Planning Services Sign Permit Review Form

Date of Submittal	Application Number	Applicant	Landowner
9/10/2025	SIGN2509-0004	Signs Unlimited	G & J Development LLC.

Contact Person	Desi Varsel	Contact Number	919-552-8689
Sign Location	McLean Chapel Church Road	PIN Number	0546-04-8107.000

Reviewed By:	Date of Review	Review Results
Randy Baker	9/12/2025	☐ Approved ☒ Denied

THIS PLAT IS PART OF A 5 SHEET SET AND
IS NOT INTENDED TO STAND ALONE. SEE ALL
SHEETS FOR NOTES, SEALS AND OTHER
INFORMATION. SHEET 2 OF 5

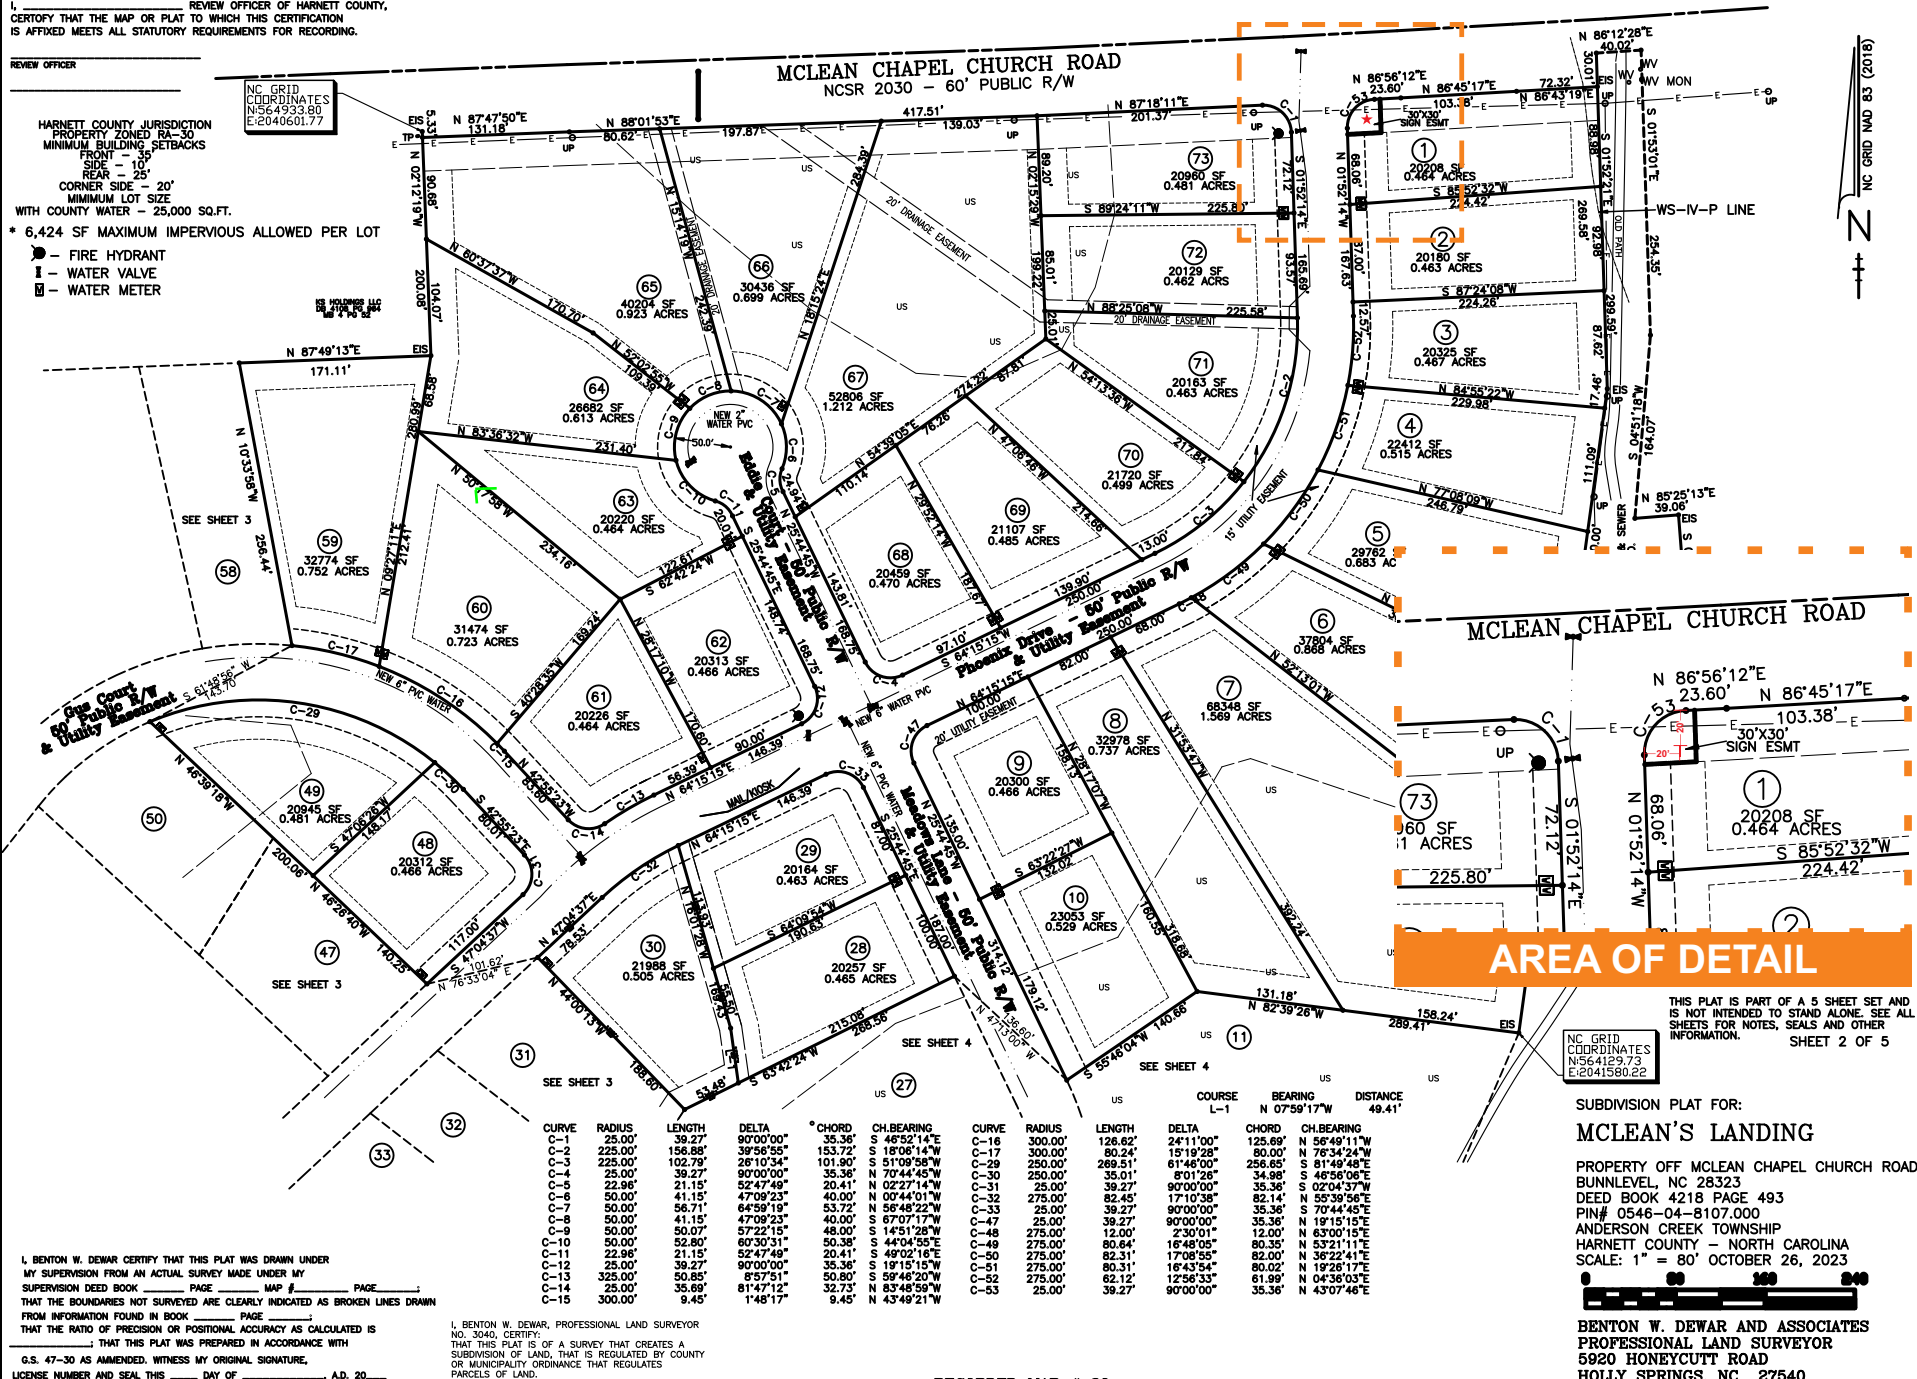
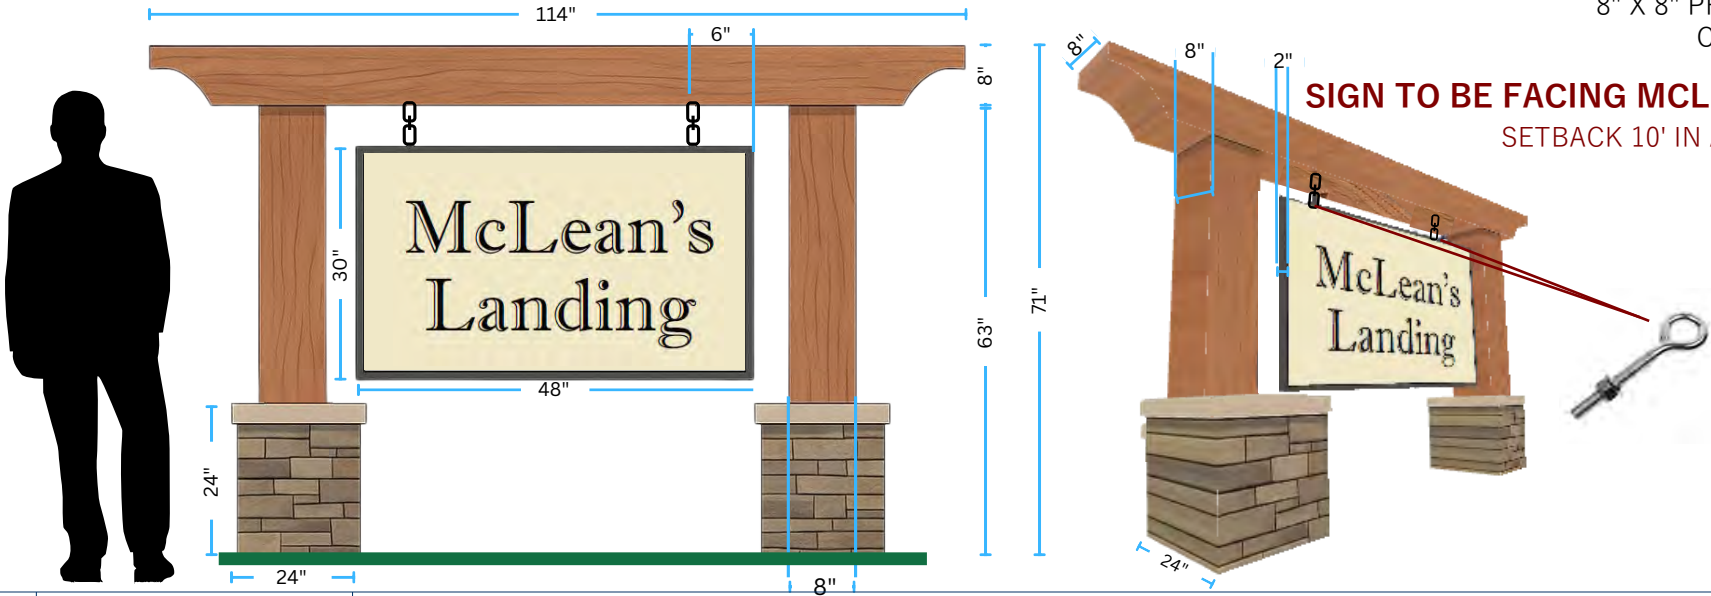
Comments	In cases where signs are placed at intersections, the minimum setback shall be 20 feet as measured from each right-of-way line or property line in both directions.
----------	---
